Environmental Health Consultation Response

To	Hebe Smith
Date	01-10-2026
Planning Ref	BR/171/26/PL
Site Description	32 London Road Bognor Regis West Sussex PO21 1PY
Date of Application	2026-09-30 00:00:00
Category	Application
Recommendation	No Objection No Objection — with conditions Objection Holding Objection

Planning Response BR-171-26-PL - 32 London Road, Bognor Regis, West Sussex, PO21 1PY

Rear West Elevation as Proposed
Scale 1:50

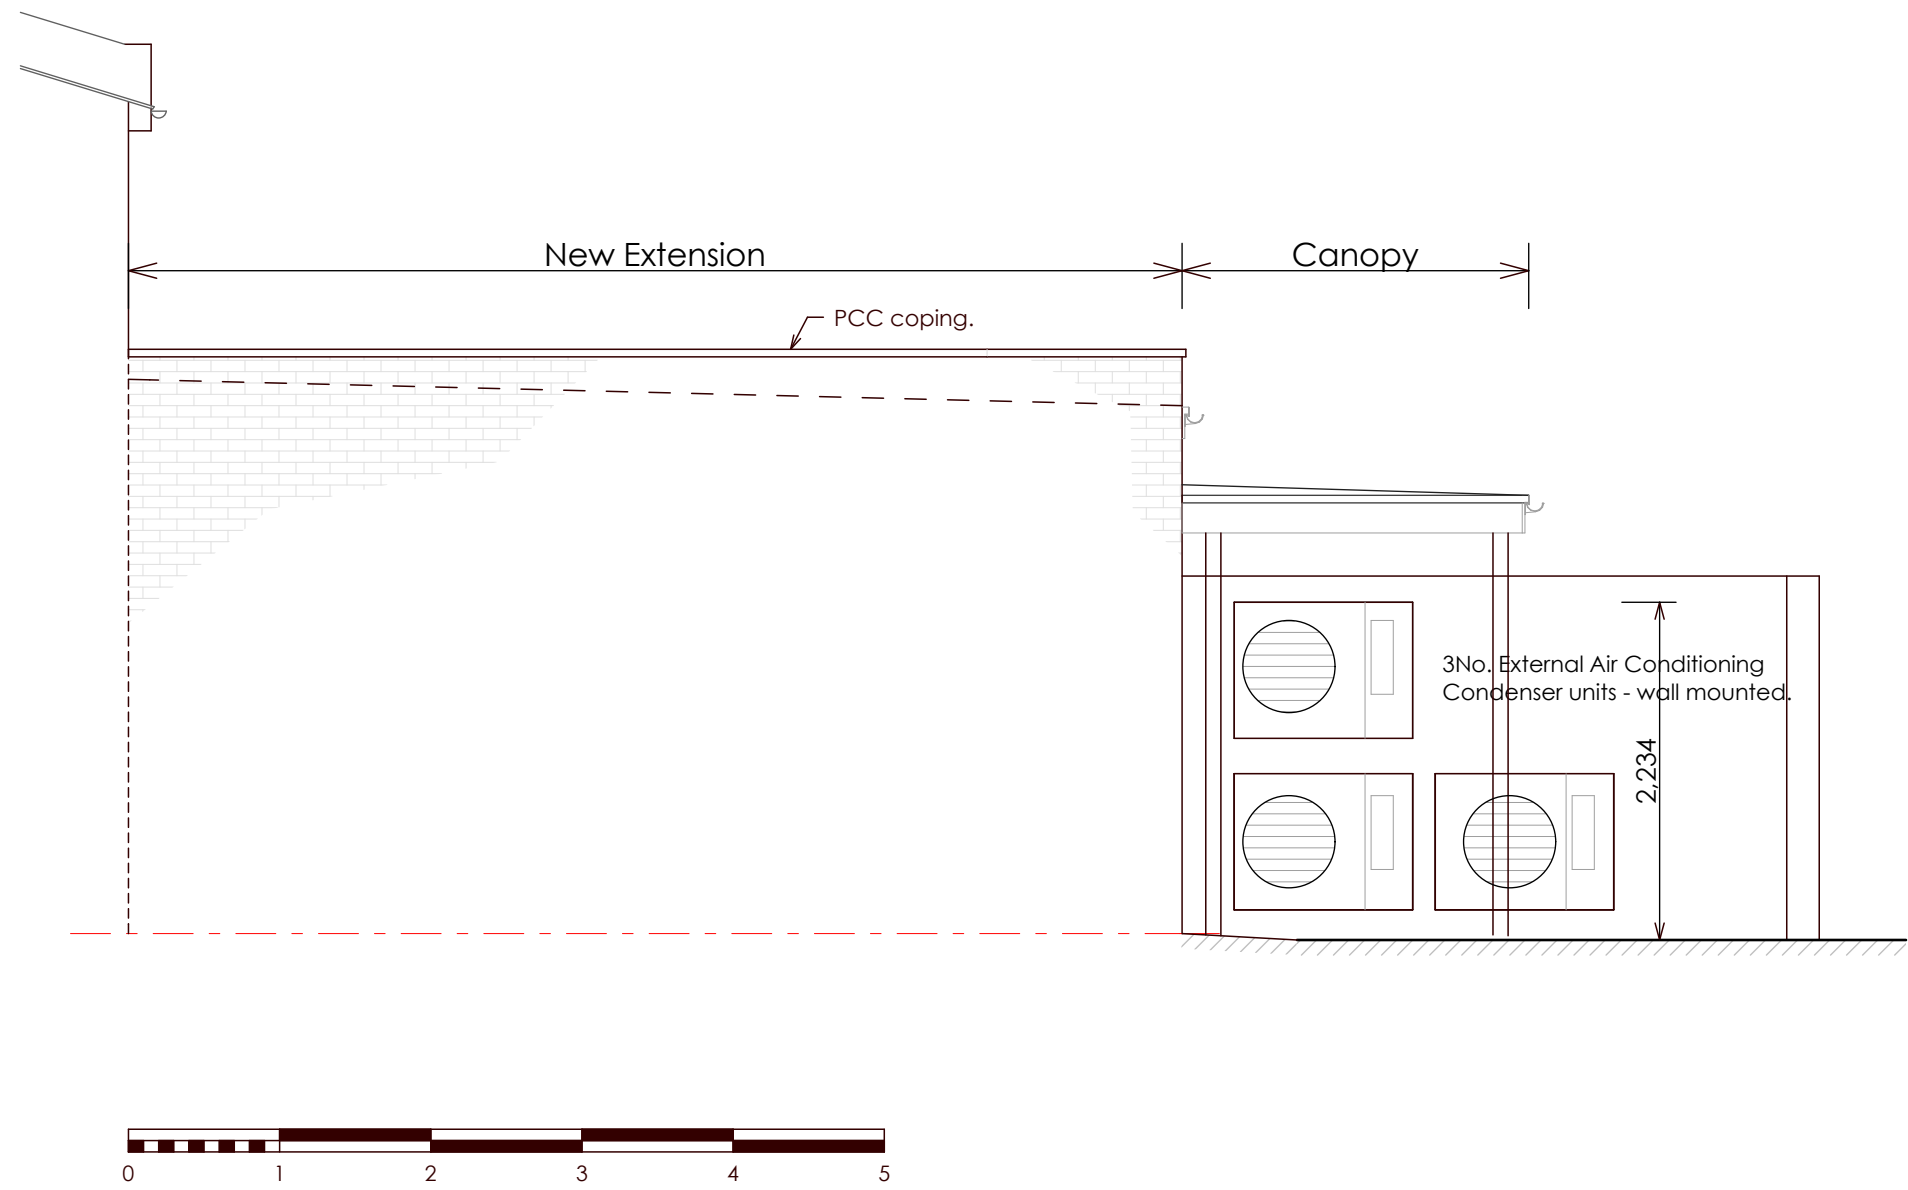
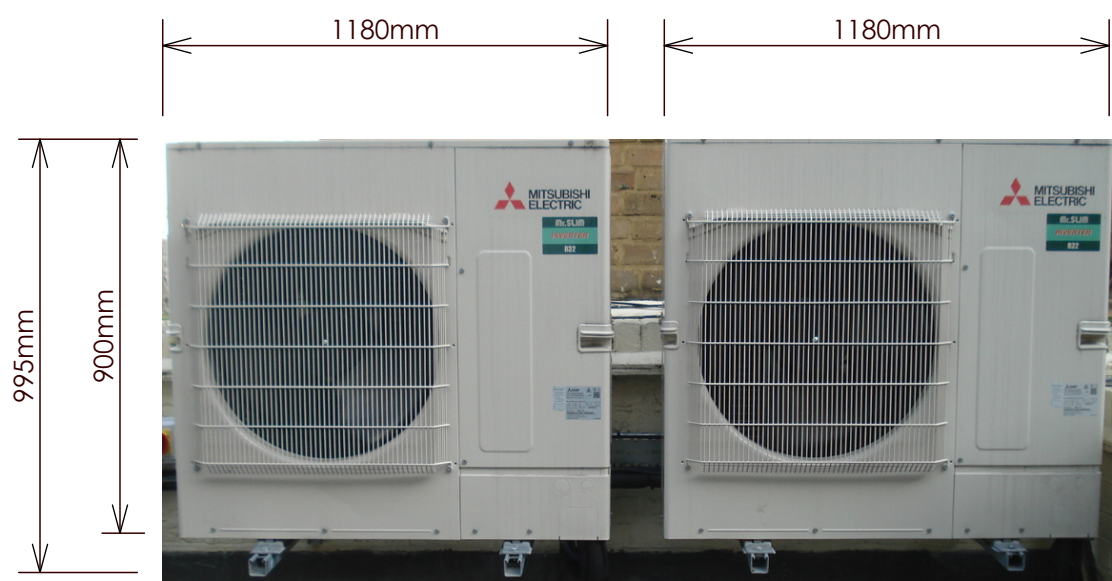
The above application proposes the installation of three air-conditioning units. No acoustic data or noise impact assessment has been submitted and, as a result, it is not possible to predict the rating sound level from the proposed plant or assess the likely impact on nearby noise-sensitive receptors.

Having regard to the location and position of the units, the proposal may be capable of being acceptable; however, this cannot be confirmed without suitable acoustic evidence. A noise impact assessment, prepared by a suitably competent person in accordance with BS 4142:2014+A1:2019, should therefore be submitted.

The assessment should include representative background sound measurements, the cumulative rating level of all three units, any applicable acoustic-feature corrections, an assessment at the nearest noise-sensitive receptors and details of any mitigation required. I would recommend a holding objection until this information is submitted.
